Application No: FP/70/21/PL
Site Address: Kenwood Court 6 The Midway Felpham PO22 7EZ
Description of works: Erection of a car port and rearrangement of existing parking spaces. This application is in CIL Zone 4 (Zero Rated) as other development.

Thank you for your internet representation made on 19th May 2021 which has been recorded as an objection with the comments as follows:

**PROPOSED CAR PORT
PLANS AND ELEVATIONS**

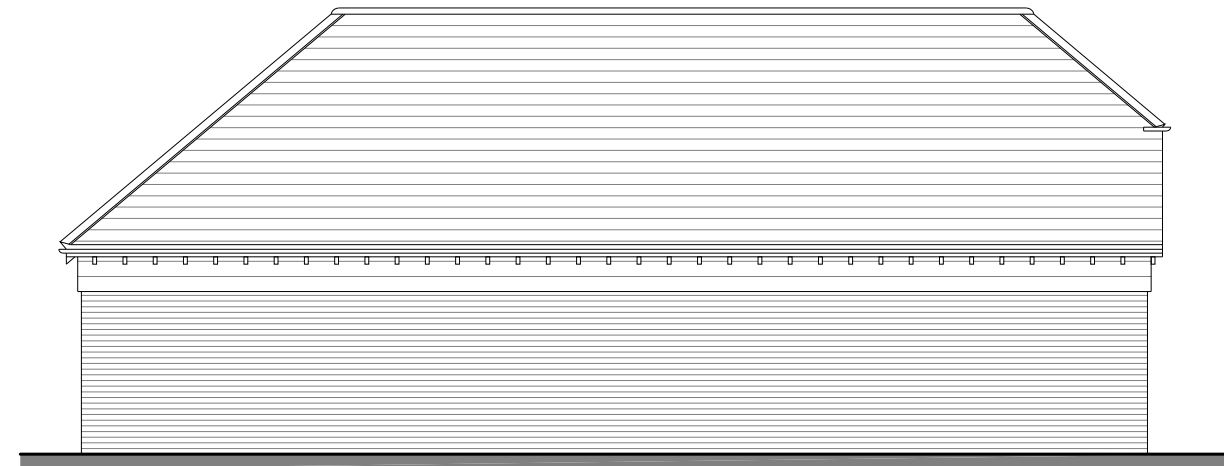
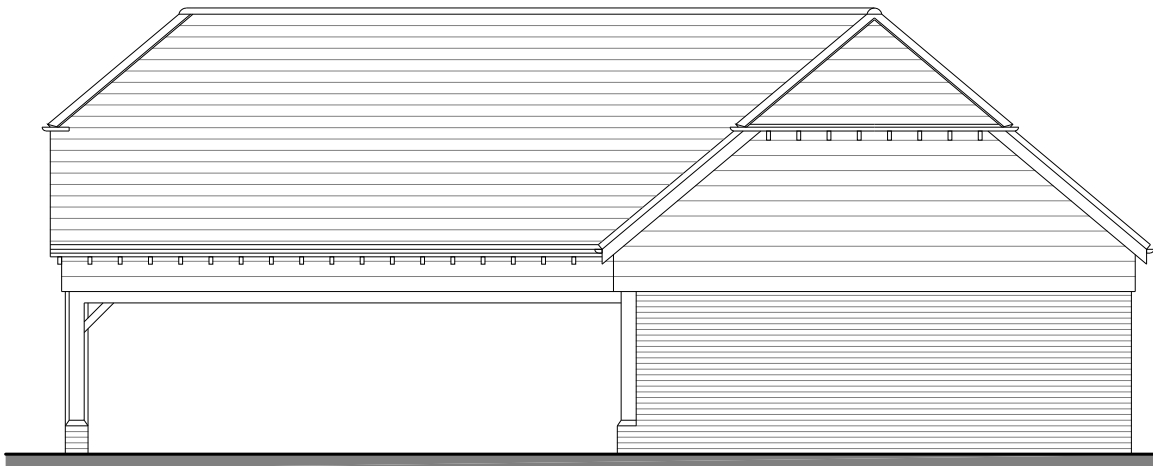
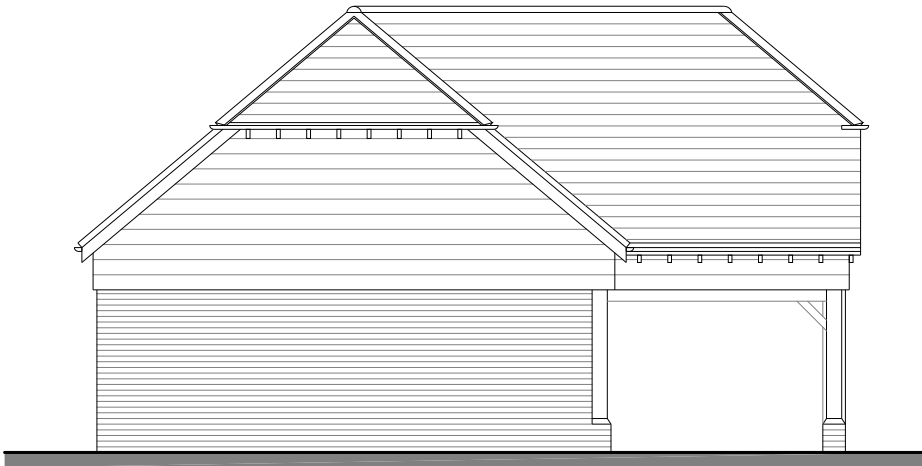
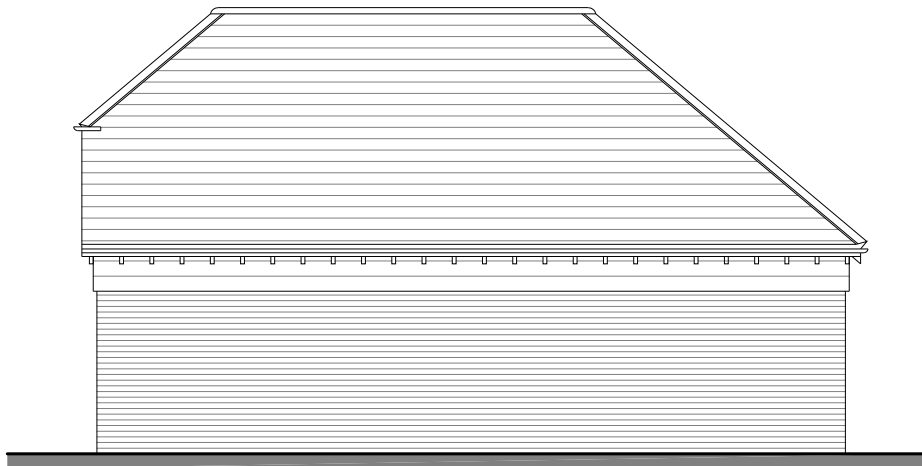
Proposed height unnecessarily high which will be very visible and obtrusive from my first floor. It will impact on properties on its southern, western and northern boundaries. I am concerned that this high structure is a prerequisite for a dwelling.
